From: [Maria Clarke](#)
To: [Jeremiah Cromie](#)
Subject: Comments that apply to VA 23 00003
Date: Friday, May 12, 2023 12:21:55 PM

Zoning Variance Application
Land Owner Sparks Park LLC C/O Lisa Weis
Agent AJ Sandhu
Tax Parcel number: 778834

PRELIMINARY SITE PLAN
 MOUNTVIEW GROUP LLC TRAVEL CENTER
 WEST SPARKS ROAD
 EASTON, WASHINGTON

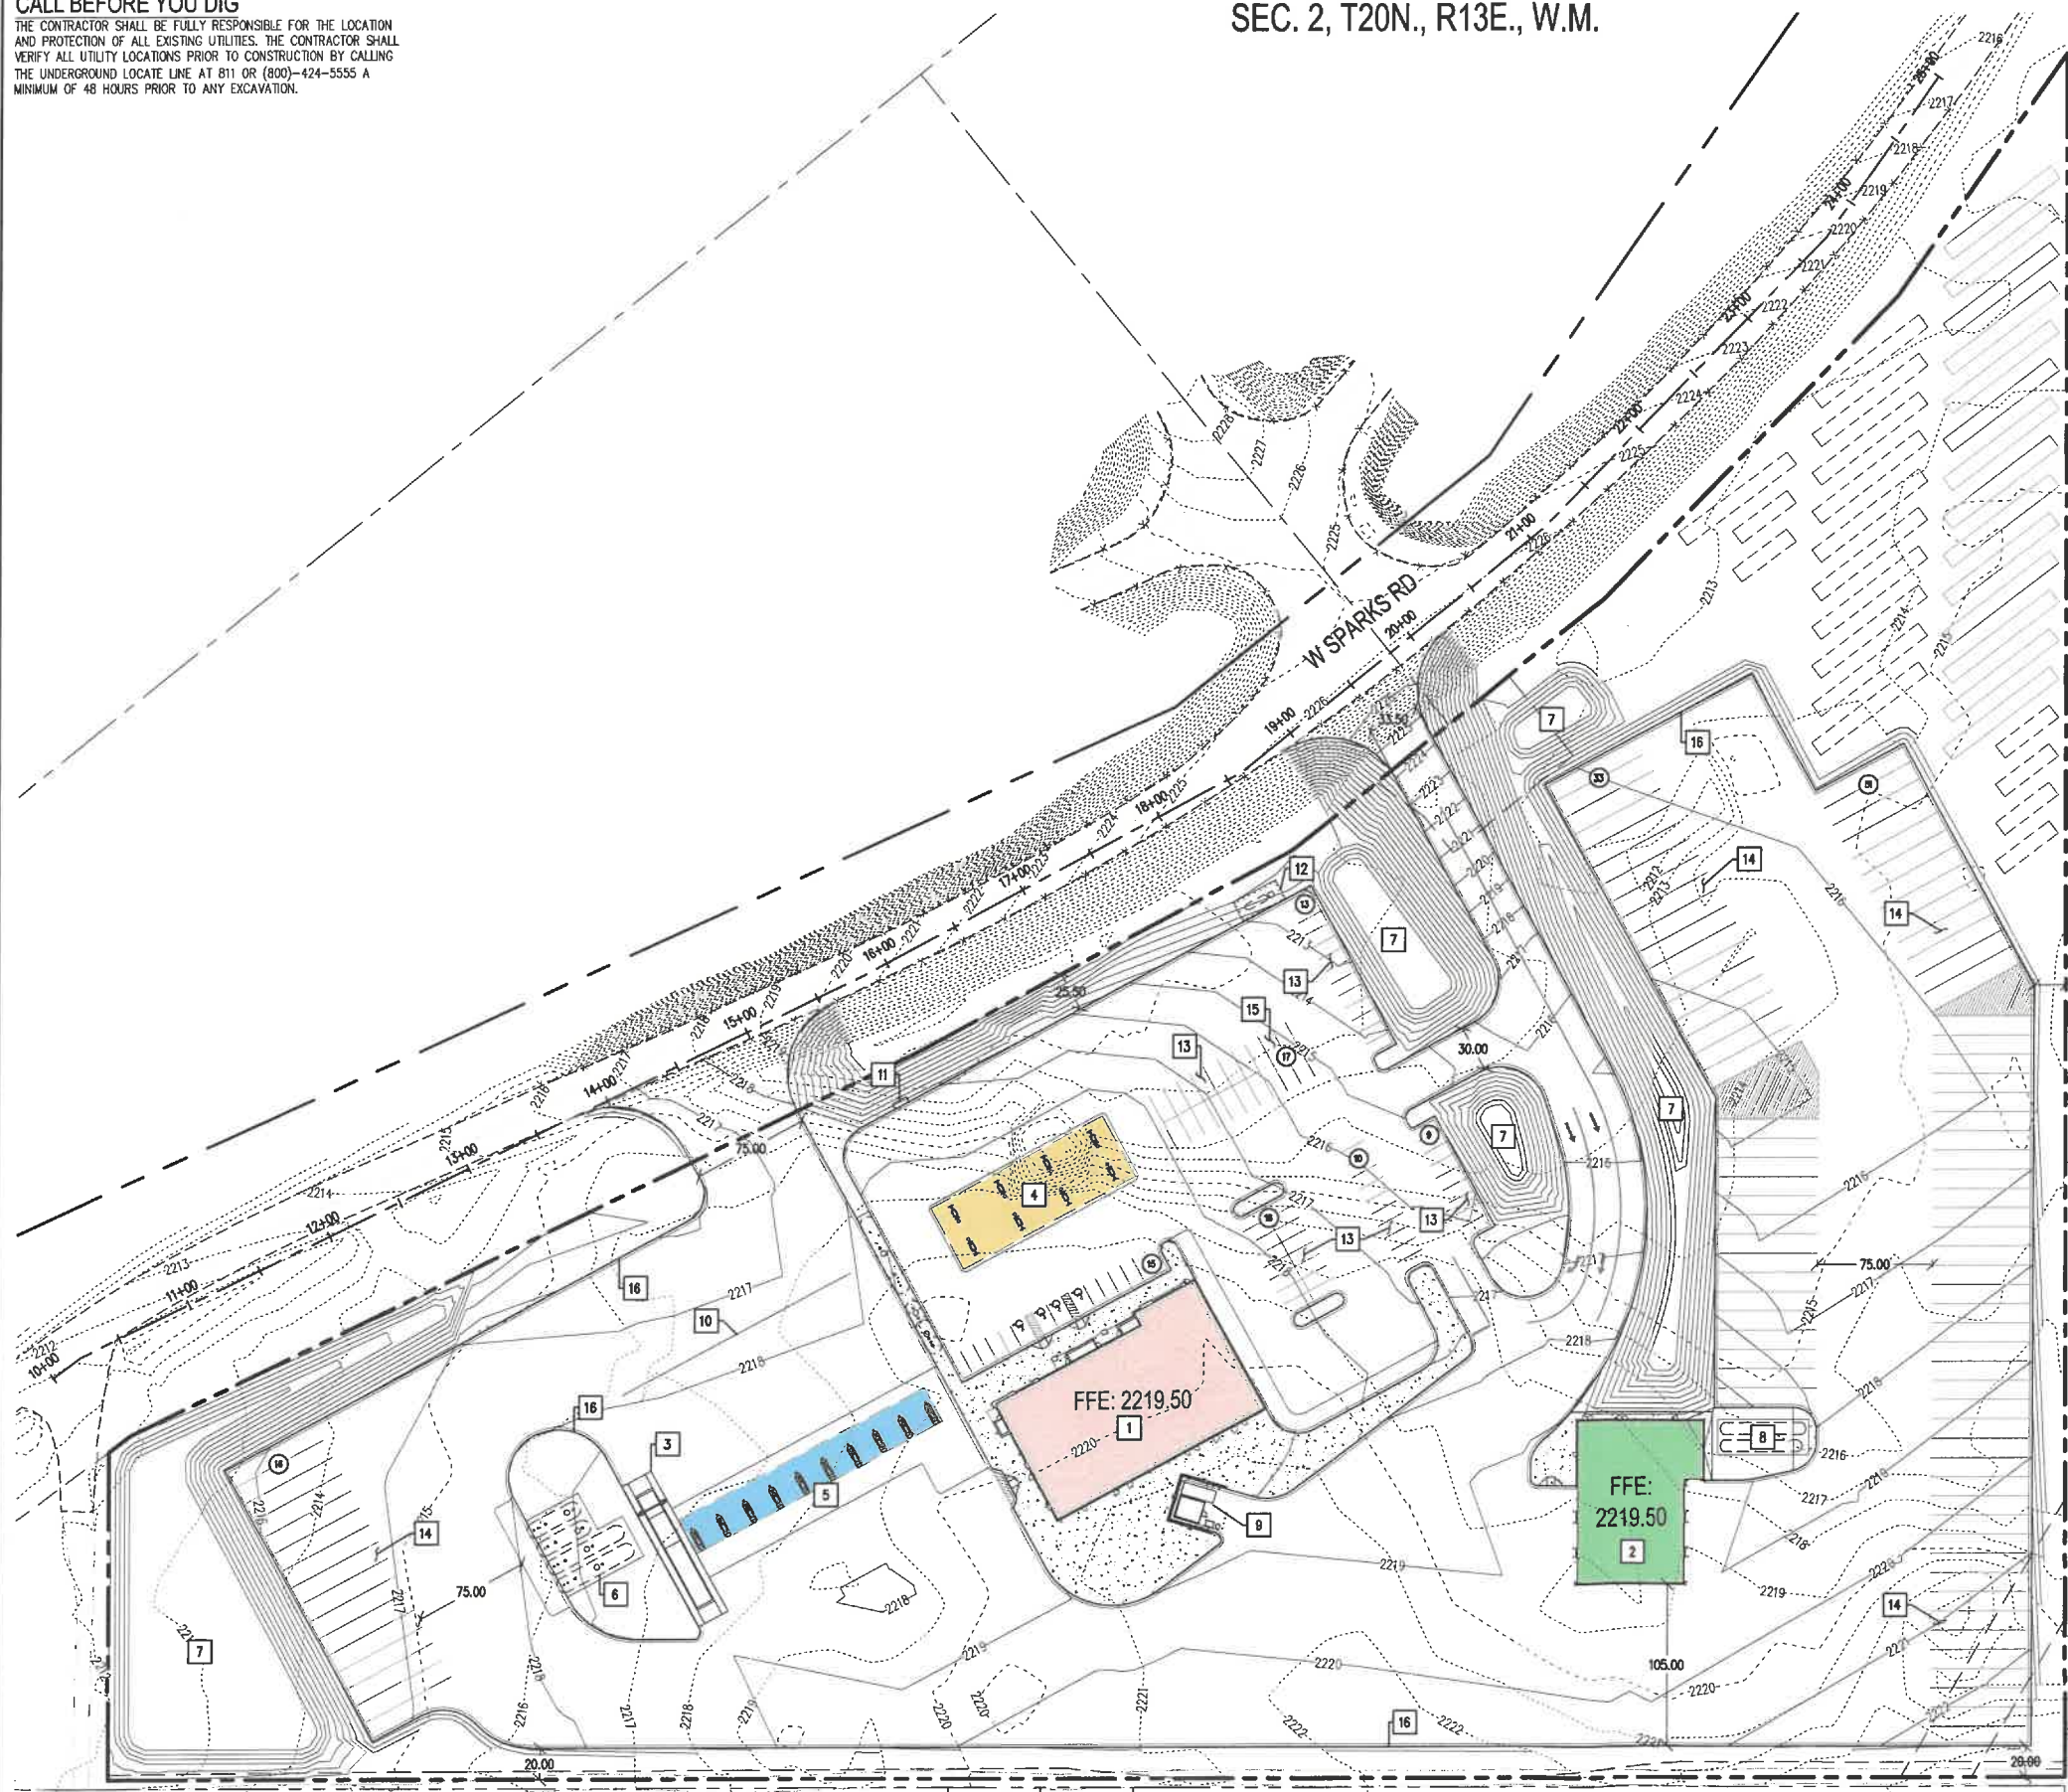
The Preliminary Site Plan does not clearly identify Septic tank, drain field and replacement area. The document is almost impossible to read due to the poor quality. It is difficult to tell if the additional items required by the Site Plan submittal are included in the submitted document. Without clarity it is difficult if not impossible to make constructive comments on this document.

The applicant also indicates that along with the difficult access there is highly restricted visibility due to the lower site topography. The topography should be of concern regarding run off especially volumes from snow melt. Also of concern is the fact that the designated truck parking is at the lower portion of the parcel which will likely cause a considerable challenge to trucks using that area during snow events causing a possible traffic flow problem at ingress and egress points.

I do not believe the applicant has presented documentation that would justify the requested variance. The request is **excessive**. Requesting more than 100% increase in impervious surface area and Retail space is not in keeping with the preservation of rural character mandated by the County’s Comprehensive Plan.
